Ref: R/190/13

Re: :and to the rear of 20 and 22 Broadmark Lane, Rustington.

We STRONGLY OBJECT to the proposed planning application for a large detached dwelling at the above mentioned site.

DRAWING TITLE
PROPOSED ELEVATIONS AND
STREET ELEVATION

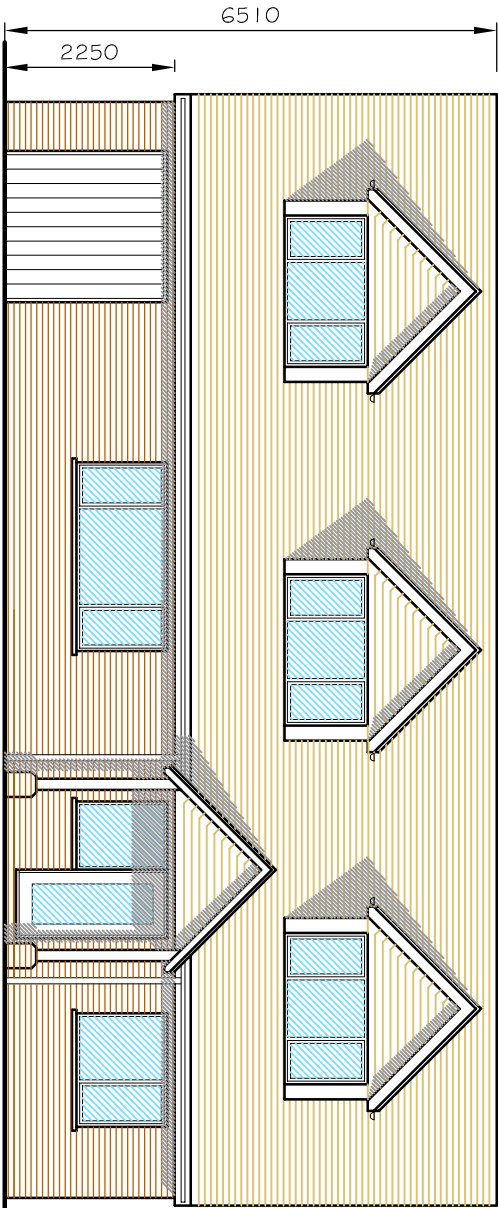
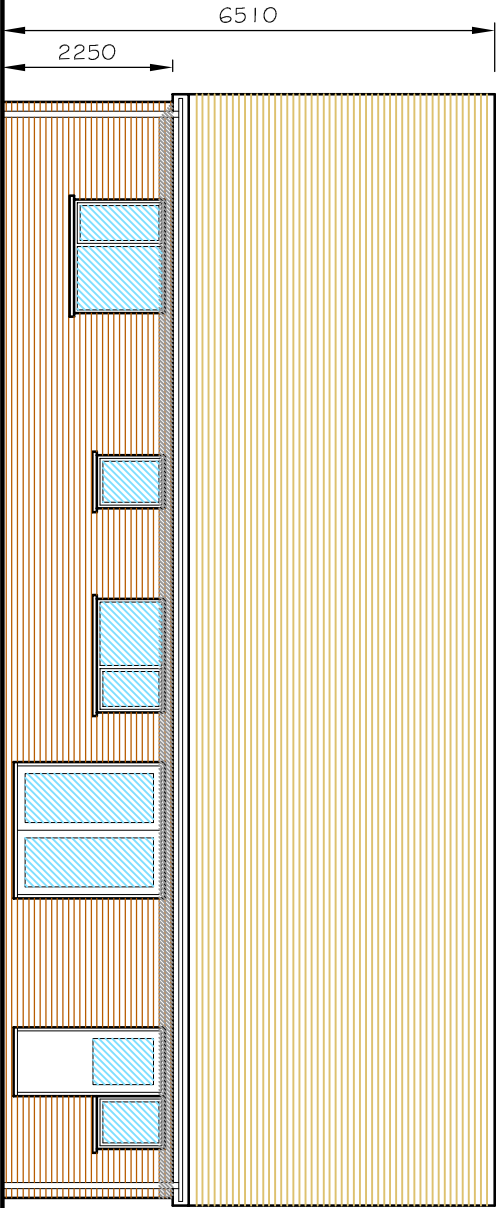
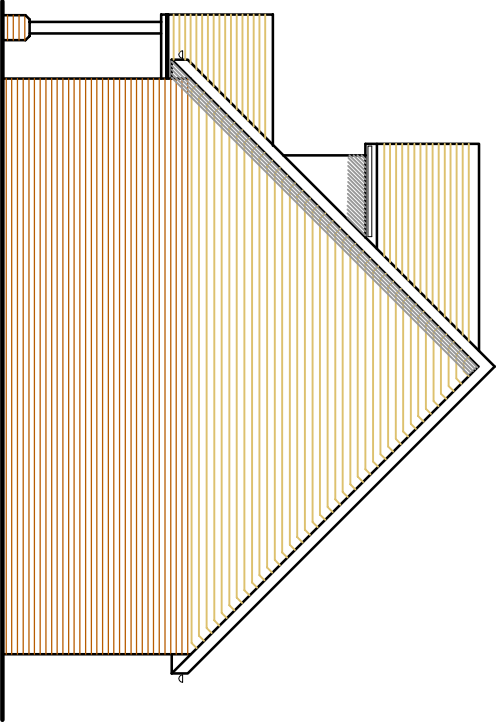
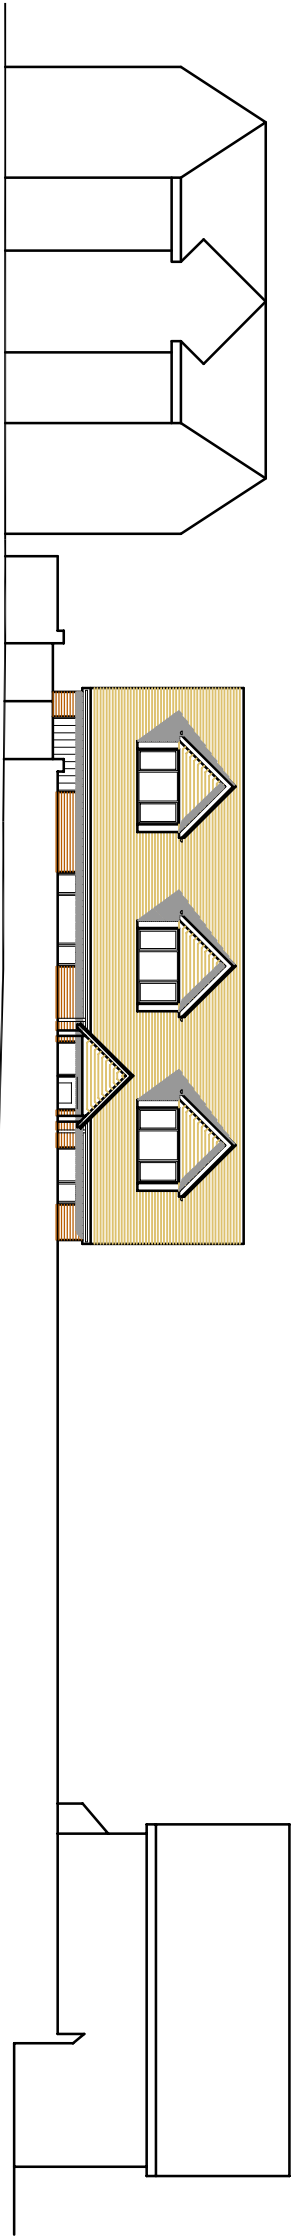
2. The proposed building will impact greatly on the neighbouring properties for a variety of reasons:
 - a) Natural sunlight will be impaired to the rear gardens of 18,20 and 22 Broadmark Lane as well as 4 Broadmark Way. The height and general size of the proposed building will result in loss of light and overshadowing of adjacent dwellings.

- e) The rear wall of 20 Broadmark Lane will be close to the proposed build - approximately 9-10 metres and this will over shadow the home and privacy for a family.

DRAWING TITLE
SITE LOCATION AND LAYOUT PLANS

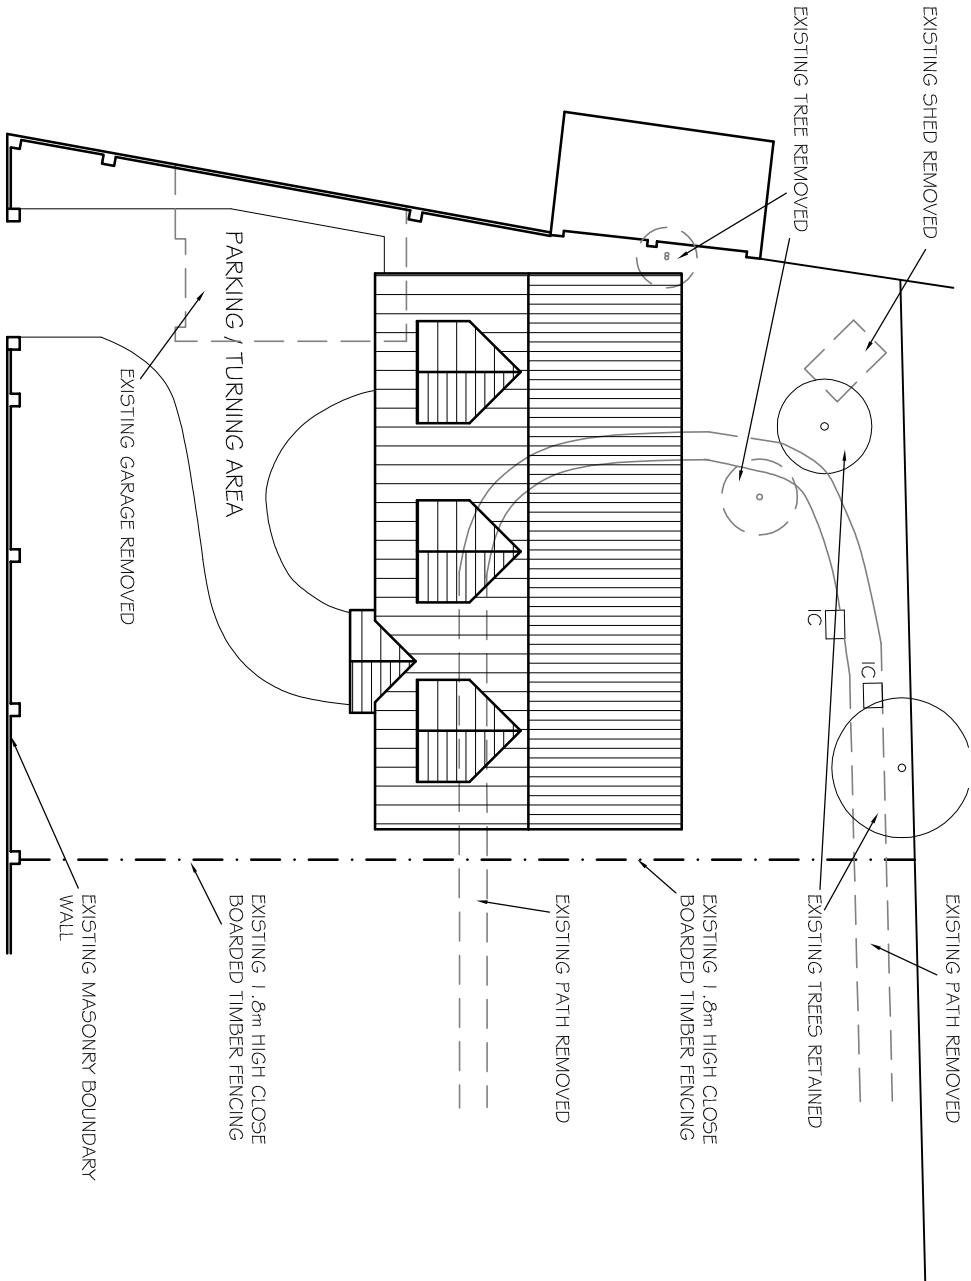
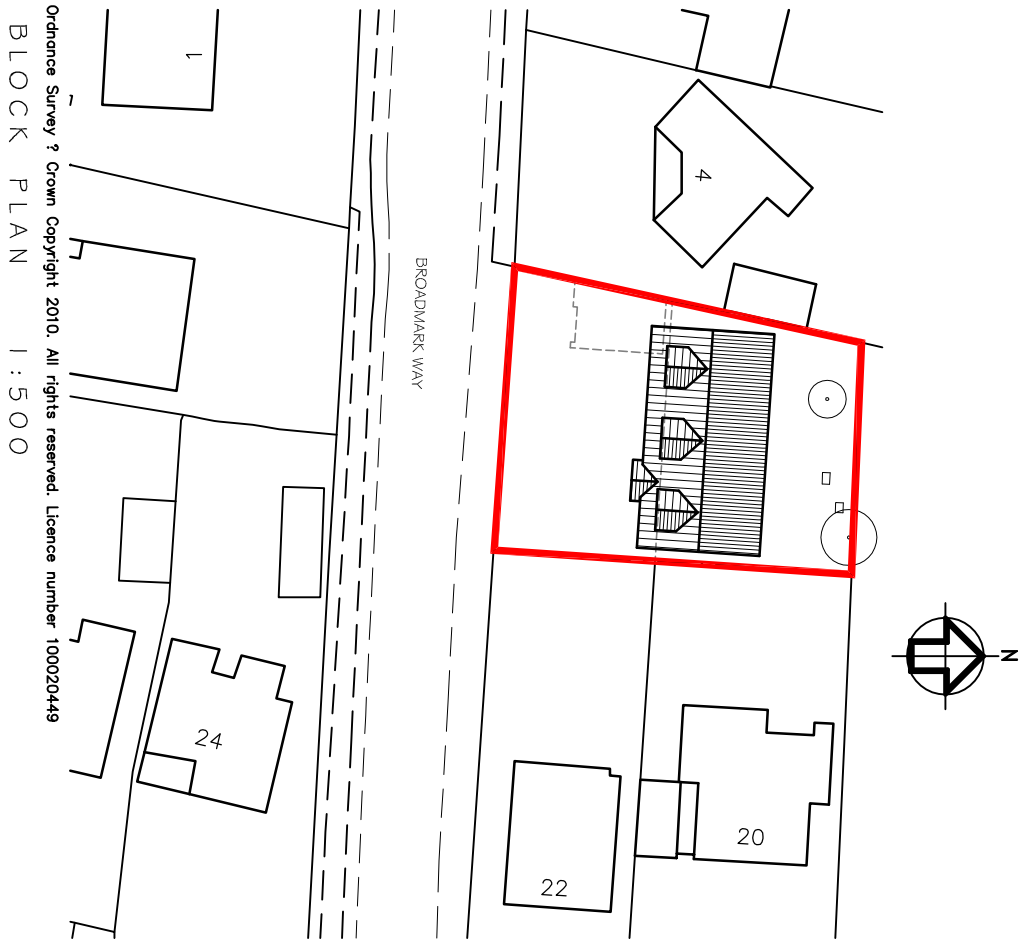
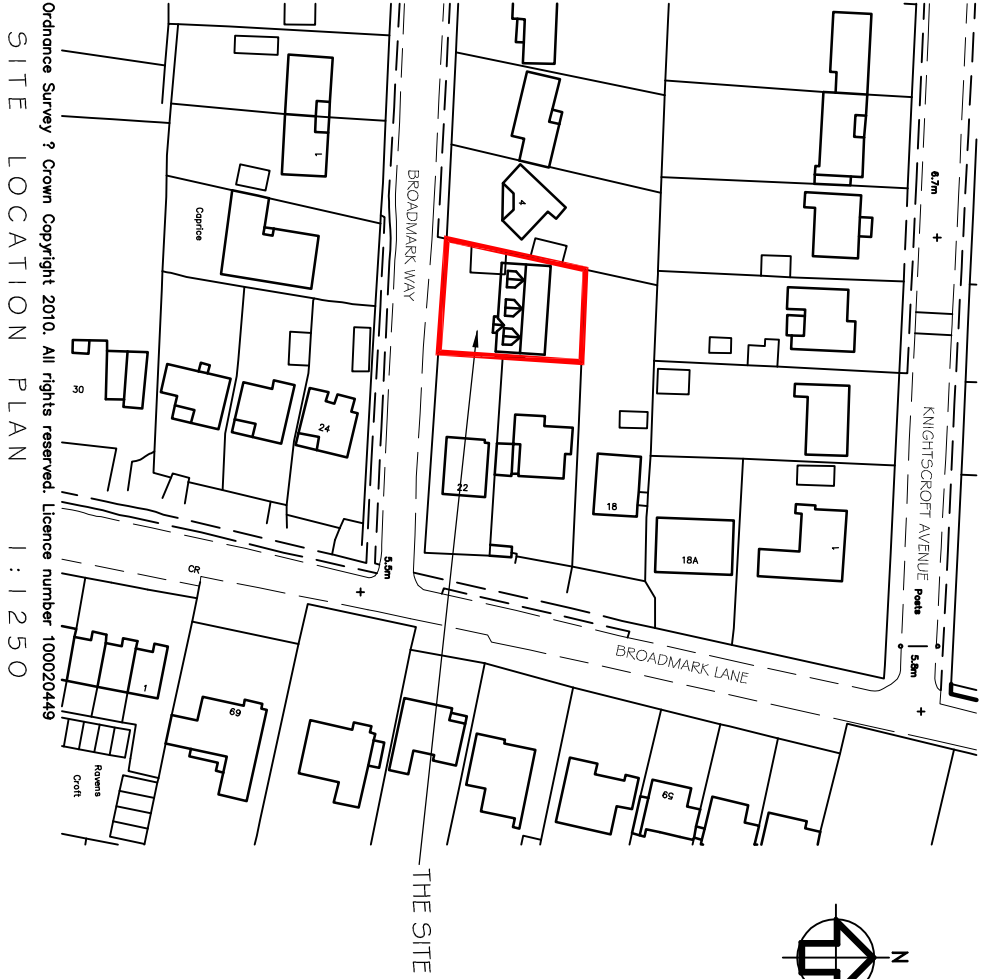
- c) Boundaries to 18,20 and 22 Broadmark Lane and 4 Broadmark Way will be in close proximity to the build and the impact to leisure and social enjoyment of outside spaces will therefore be impeded.

3. The size of the proposed site is significantly smaller than sites in the immediate and larger vicinity. This will not be in keeping of similar properties and the resulting outside space will be smaller, thus the dwelling will be even closer to surrounding properties.
